From: Bridget McNamara
Sent: Monday, 19 June 2017 10:09 AM
To: 'Michele.nettlefold@planning.nsw.gov.au' <Michele.nettlefold@planning.nsw.gov.au>
Cc: Christopher Corradi <ccorradi@cityofsydney.nsw.gov.au>
Subject: MP 08_0098 MOD 14 - Response to Submissions - R/2016/1/B

Thank you for your email. We have reviewed the response to submissions and the additional information received and the City does not object to the proposed modification, subject to the following being included/modified:

1 PROPOSED FLOOR PLAN LEVEL 05
1:250

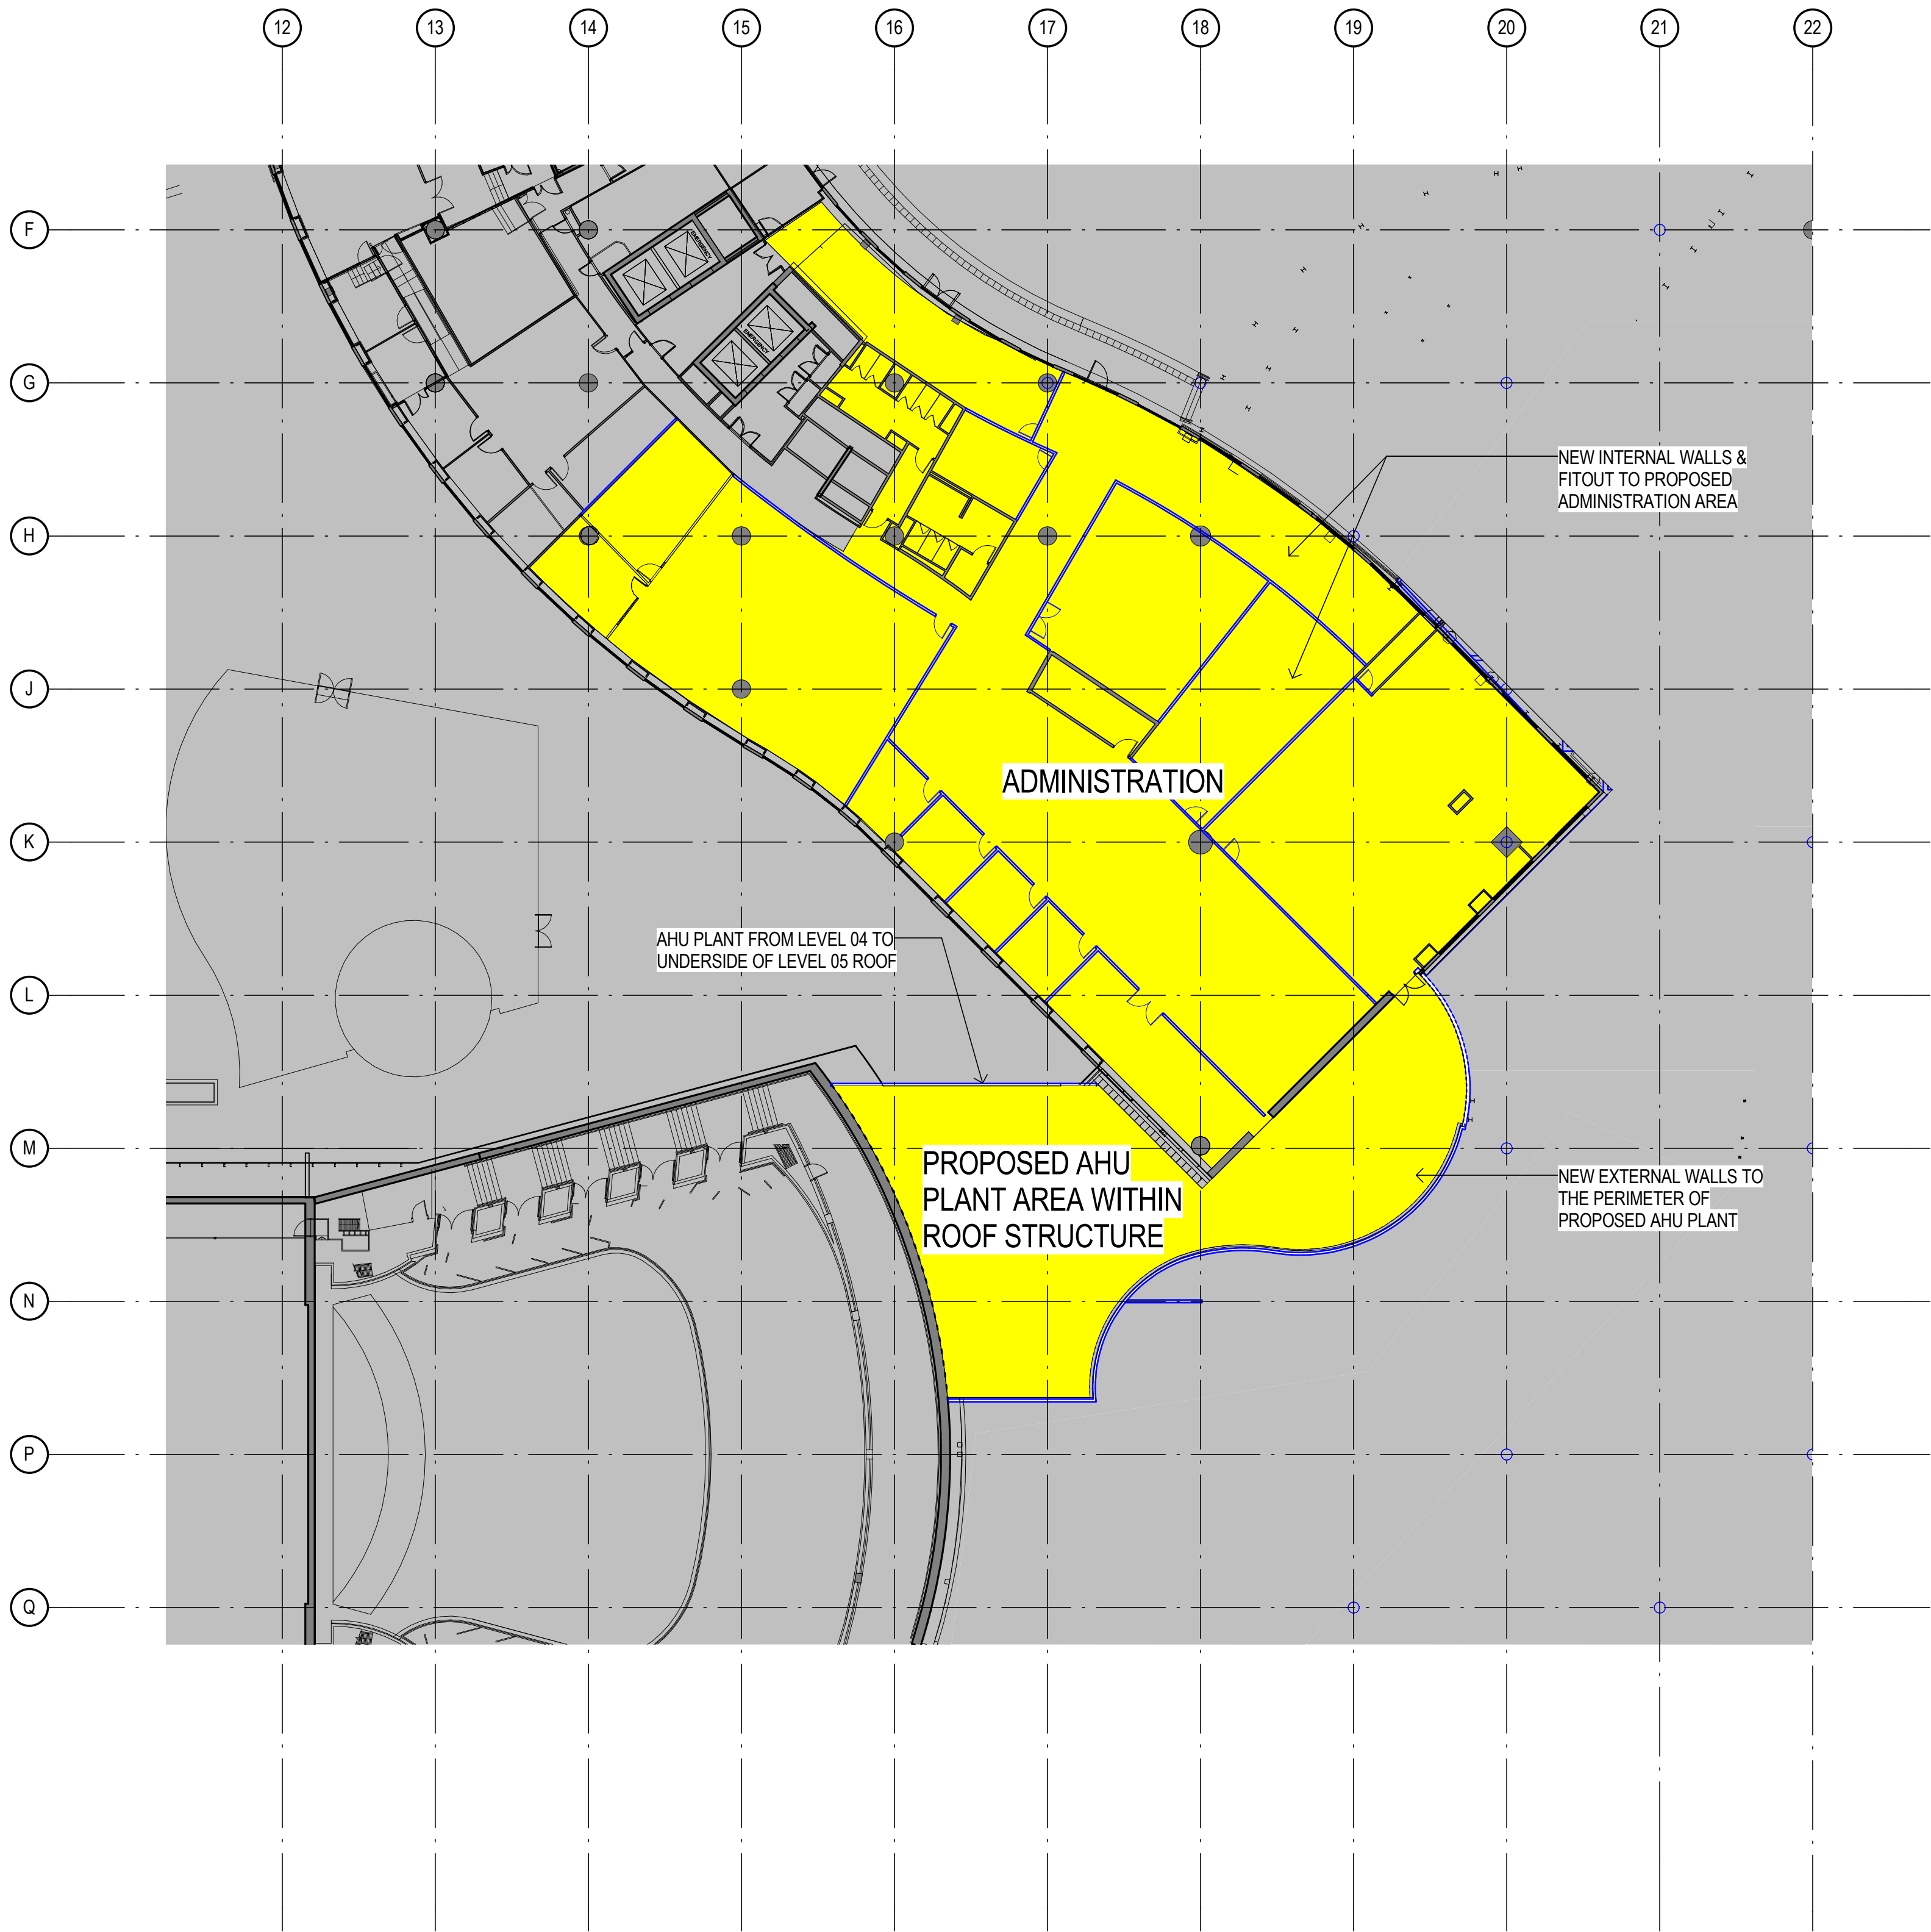
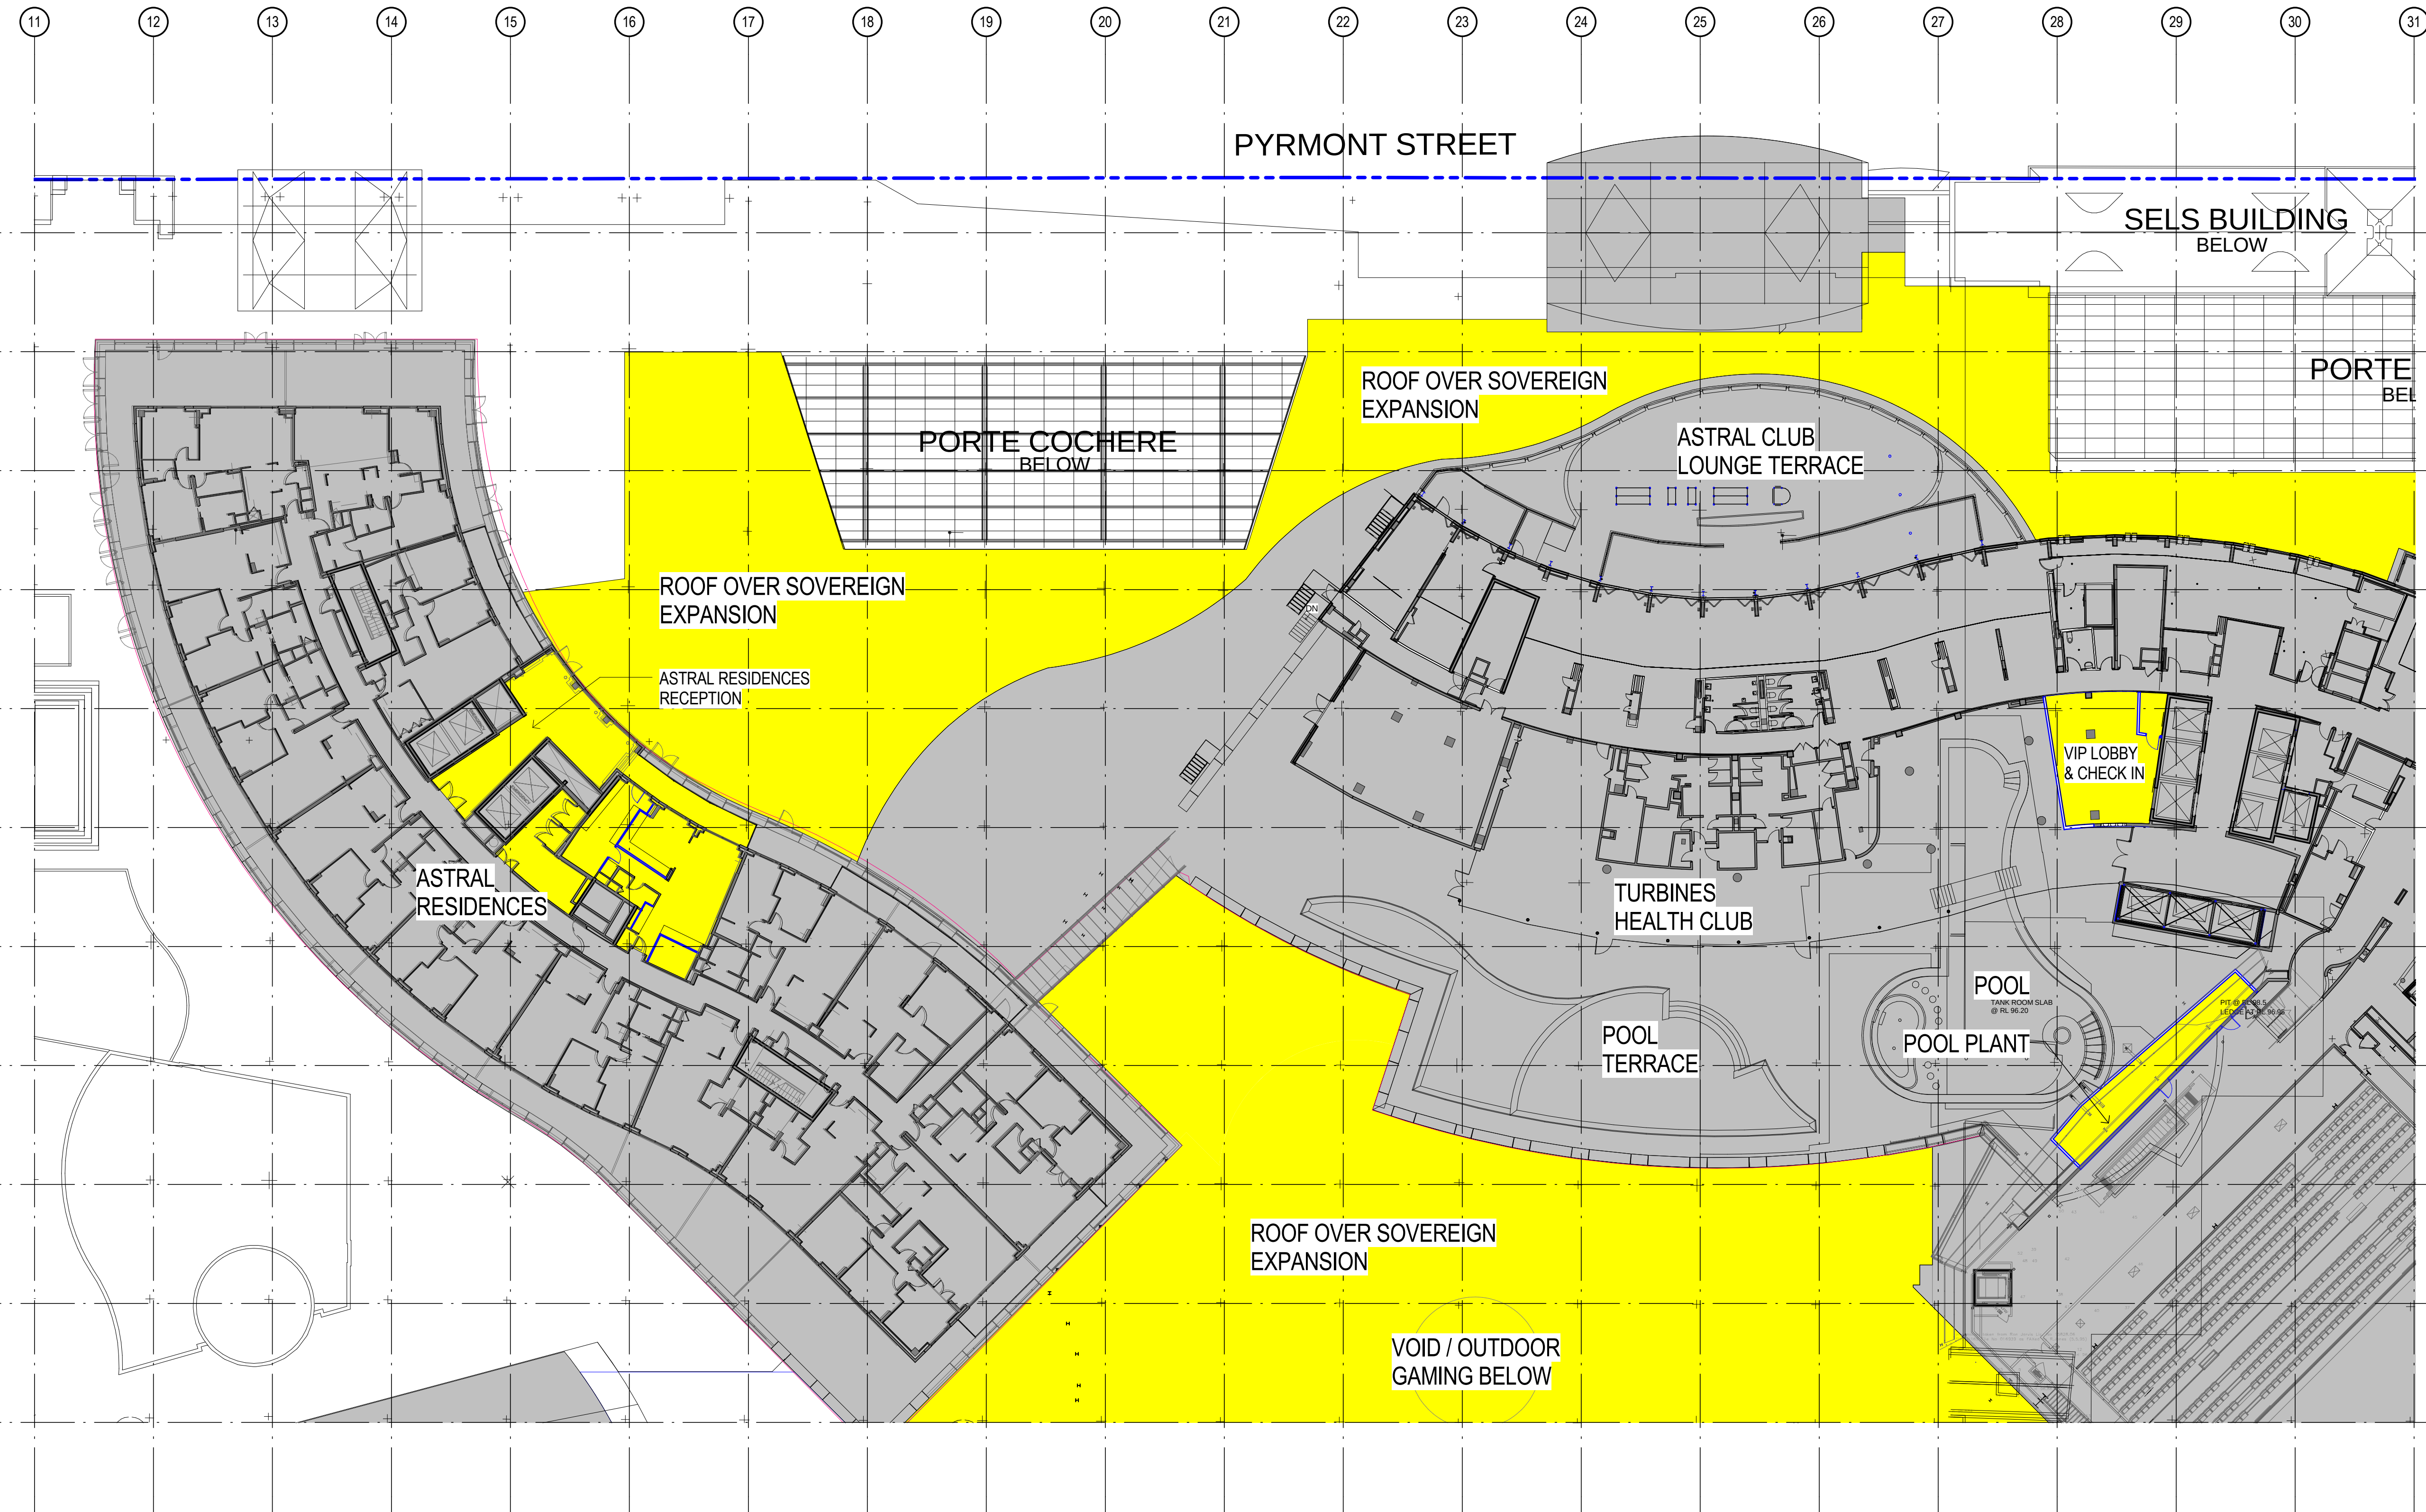
The green roof to level 5 is a welcome addition, and should make a significant contribution to reducing the heat load. However, at an approximate area of 5420sqm, there is also an opportunity to make a significant contribution to urban ecology and biodiversity. Subsequently, the proposed plant palette should be further diversified ensuring locally indigenous species are selected wherever possible, and only species with low water requirements are selected. It is therefore recommended to include a condition requiring the plant list to be developed in consultation with the City's ecologist, Sophie Golding.

- (a) A detailed plan of the green roof, drawn to scale, by a qualified landscape architect or landscape designer, must be submitted to and approved by Council's Area Planning Manager prior to the issue of a Construction Certificate. The plan must include:

- (ii) Details of earthworks including mounding and retaining walls.
 - (iii) Details of the location, sizes and numbers of plants used with reference to NATSPEC, with a preference for locally indigenous and drought resistant plants. The proposed green roof plant species are not approved, and must be selected in consultation with the City's ecologist to ensure adequate biodiversity.

1 PROPOSED FLOOR PLAN LEVEL 00-PART 1A
1: 250

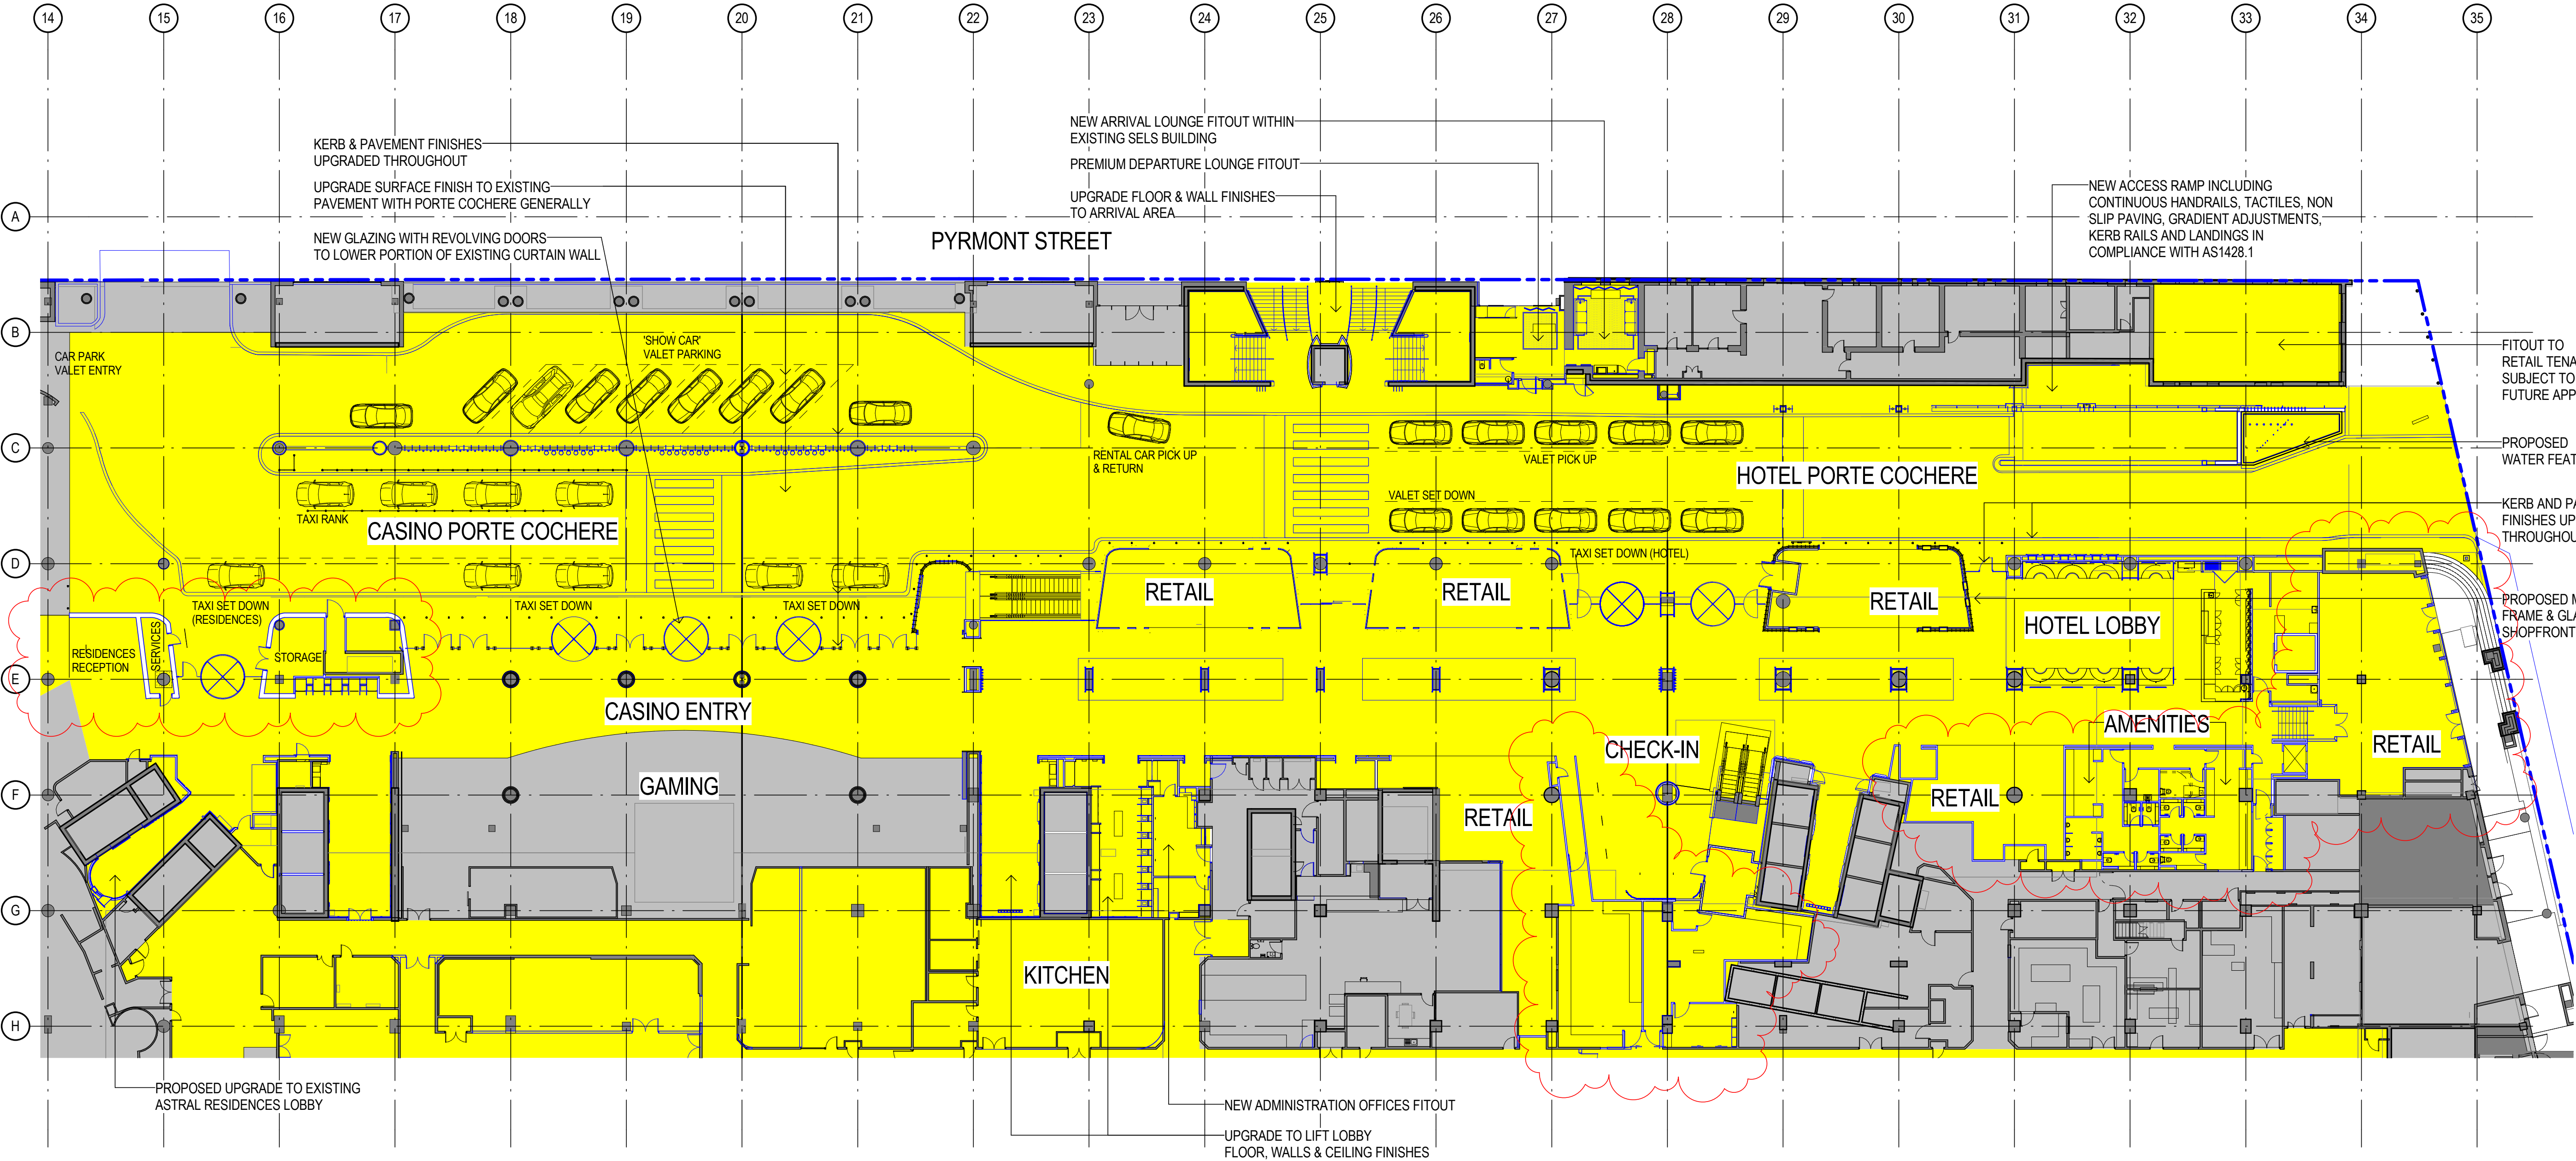
- o The proposed granite paving along Pyrmont Street is localised and centred upon their entrance. It does not address the existing state of asphalt pavement (which is in need of repair in places) nor the increased footfall that will directly result from the development. Continuing the granite pavement to the intersection with Jones Bay Road will set the public domain treatment and eventual upgrade of the rest of the road rather than presenting as a 'doormat' upgrade to suit the developments needs only.
- o The proposed upgrade of asphalt along Jones Bay Road also falls short of improving the footway for the same reasons as above. Also affected are the pedestrian crossing on Jones bay Road which requires improvement on both sides of the street to meet current standards.

- (a) A detailed Public Domain Plan must be prepared by a suitably qualified architect, urban designer, landscape architect or engineer and must be lodged with Council's Public Domain Section and be approved by Council prior to a Construction Certificate being issued for public domain work or above ground building work, whichever is later. The Public Domain Plan must be submitted with a completed Public Domain Plan checklist (available in the City of Sydney's *Public Domain Manual*).
- (b) The Public Domain Plan must document all works required to ensure that the public domain complies with the City of Sydney's *Public Domain Manual*, *Sydney Streets Design Code* and *Sydney Streets Technical Specification*, including requirements for road pavement, traffic measures, footway pavement, kerb and gutter, drainage, vehicle crossovers, pedestrian ramps,
